STAFF REPORT

Calvary Ellensburg Conditional Use Permit (CU-22-00002)

TO: Kittitas County Hearing Examiner
FROM: Jeremiah Cromie, Staff Planner
RE: Calvary Ellensburg Conditional Use Permit (CU-22-00002)
DATE: November 22, 2022 (Hearing Date)

Calvary Ellensburg Proposed Site Plan Phase I - Exhibit B

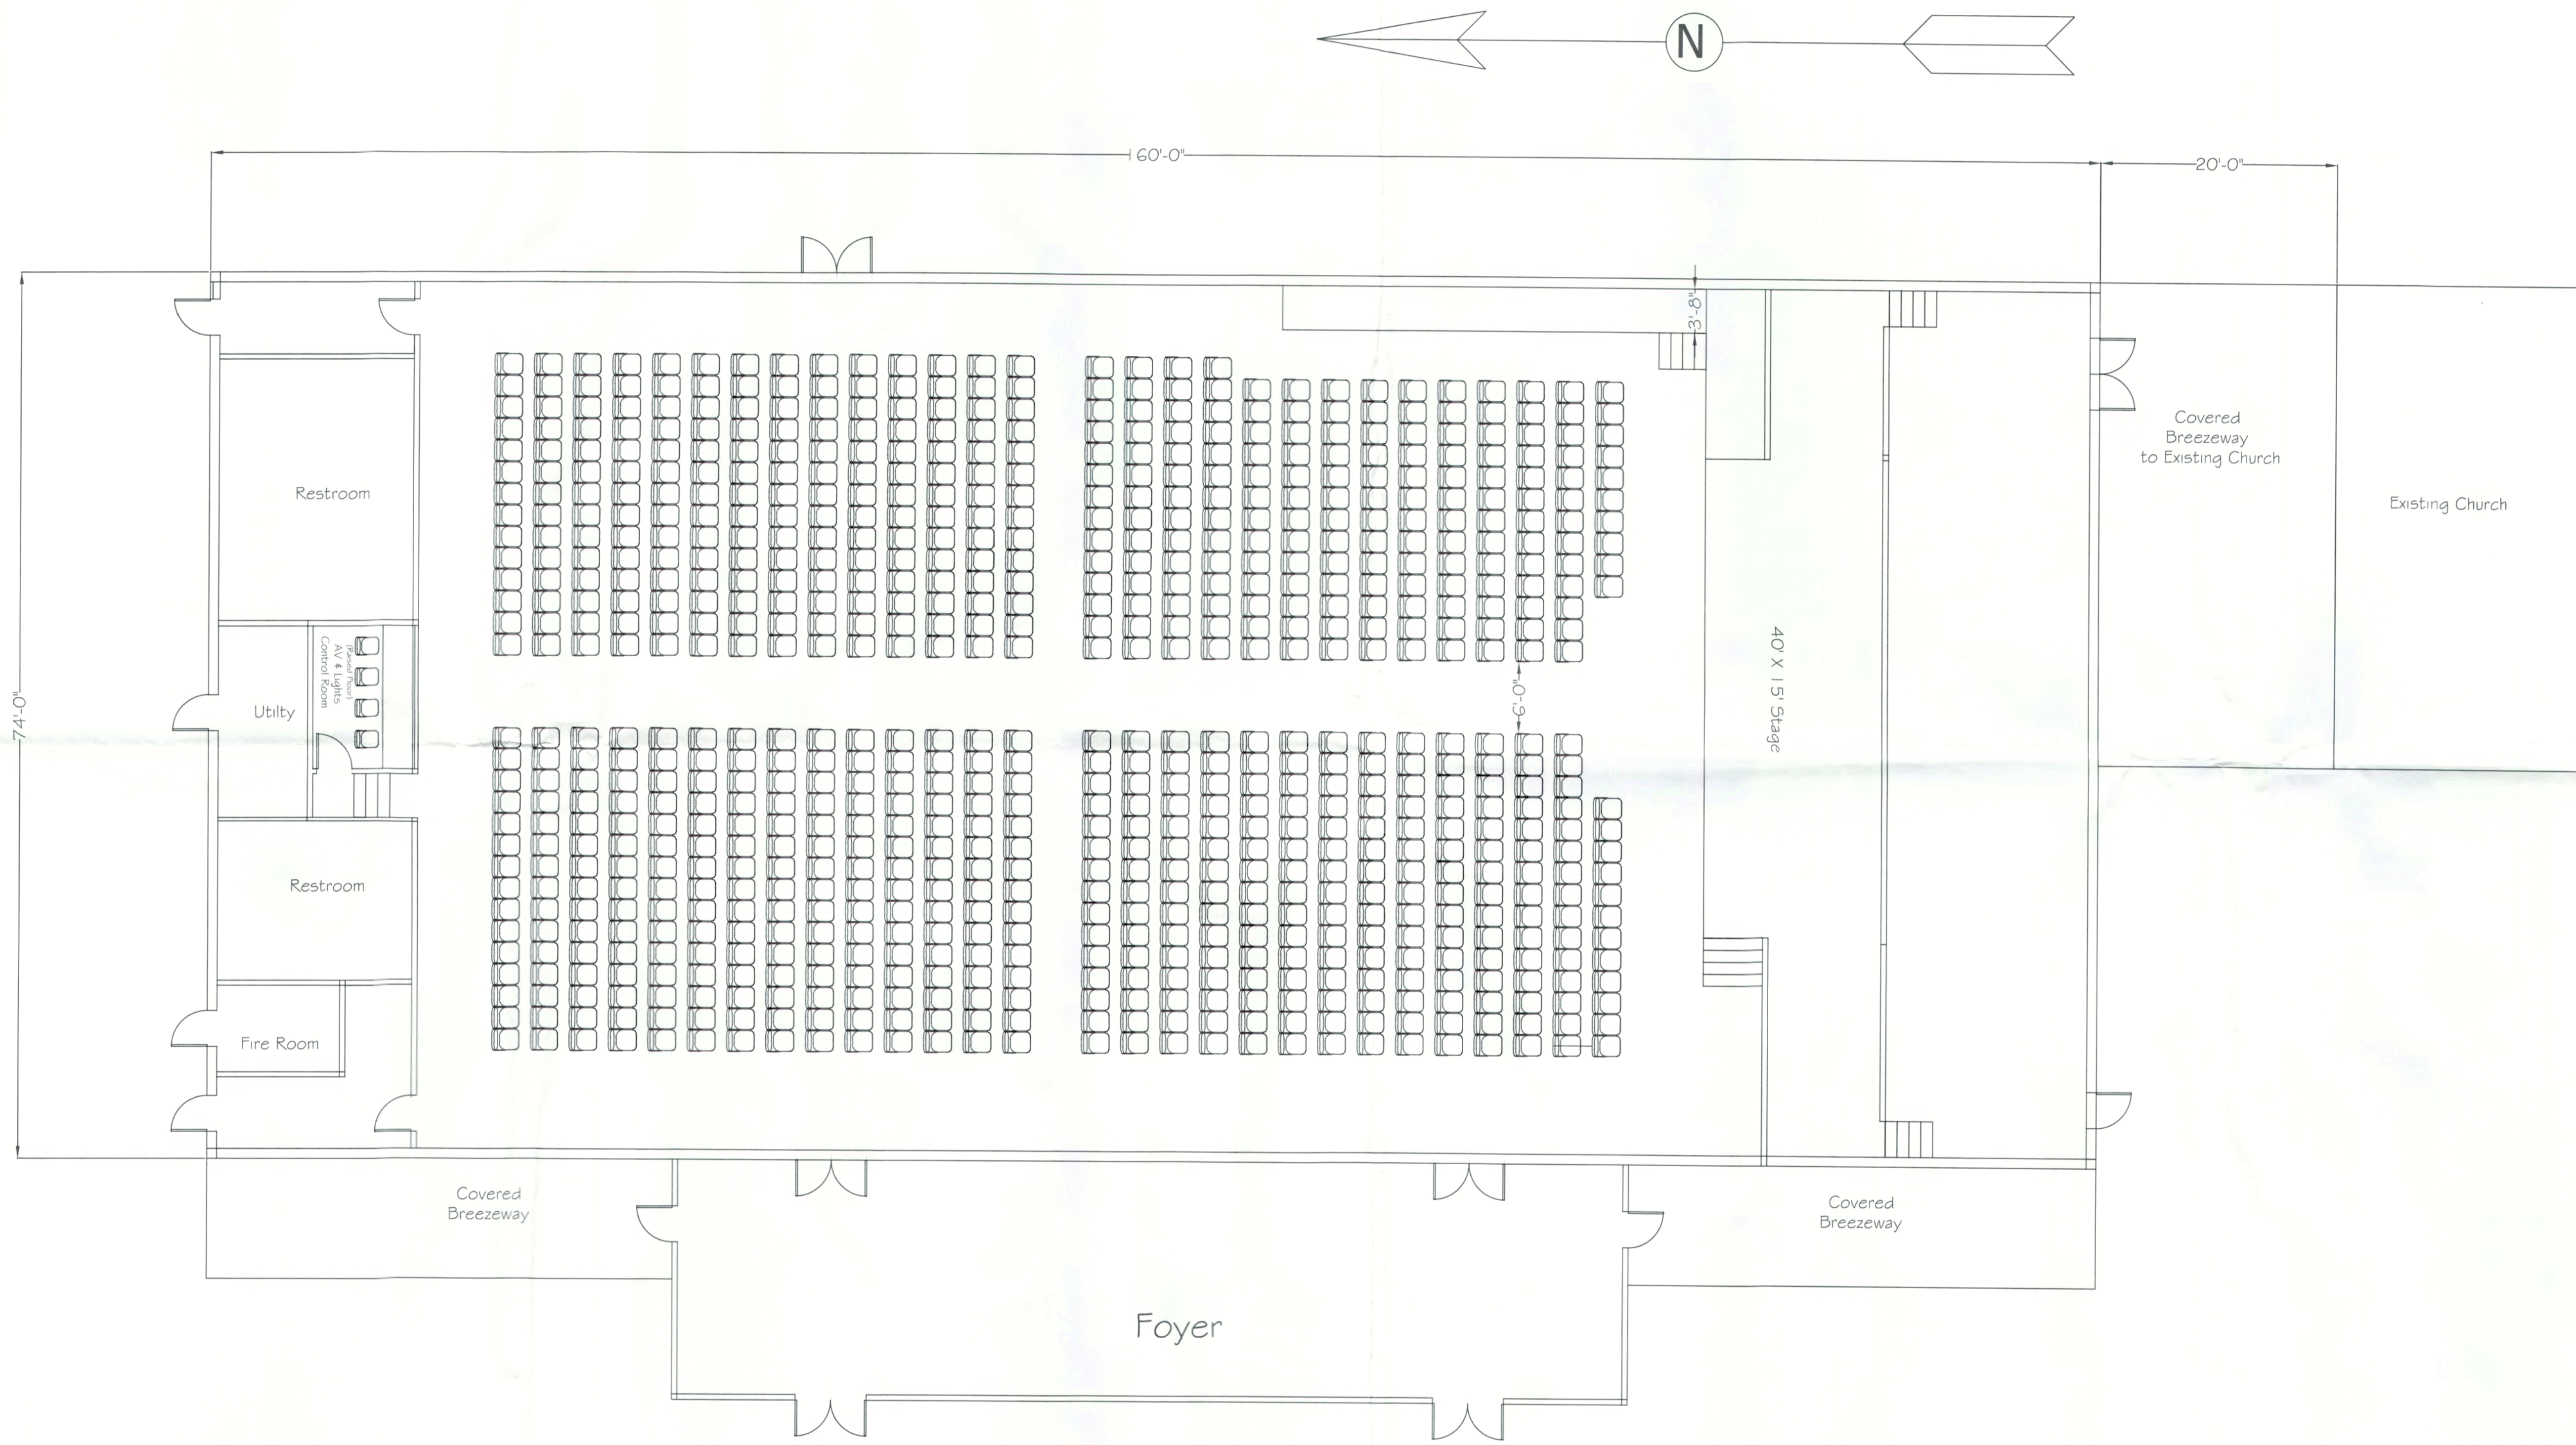
Staff Response: The use is mostly consistent with the relevant development standards and criteria in Kittitas County Code. The expanded substation is permitted in the Urban Residential zone through a Conditional Use Permit under KCC 17.15.080. The setbacks for the outdoor restroom and utility building currently encroach on the required 15-foot side setback in KCC 17.22.060. These would need to be modified to meet setbacks, go through a lot line encroachment process as seen in KCC 16.10.065 or a be combined through a parcel combination. Staff has conditioned this proposal to reflect that.

1. The project shall proceed in substantial conformance with the plans and application materials on file with CDS that were revised and received on May 9, 2022 attached as Exhibit A, and subsequent information included in the complete file index except as amended by the conditions herein.
2. The proposed utility building and outdoor restroom buildings shall meet the 15-foot side setback, or the owner/applicant shall go through the lot line encroachment form seen in KCC 16.10.065 or do a parcel combination to keep them in the current proposed location.
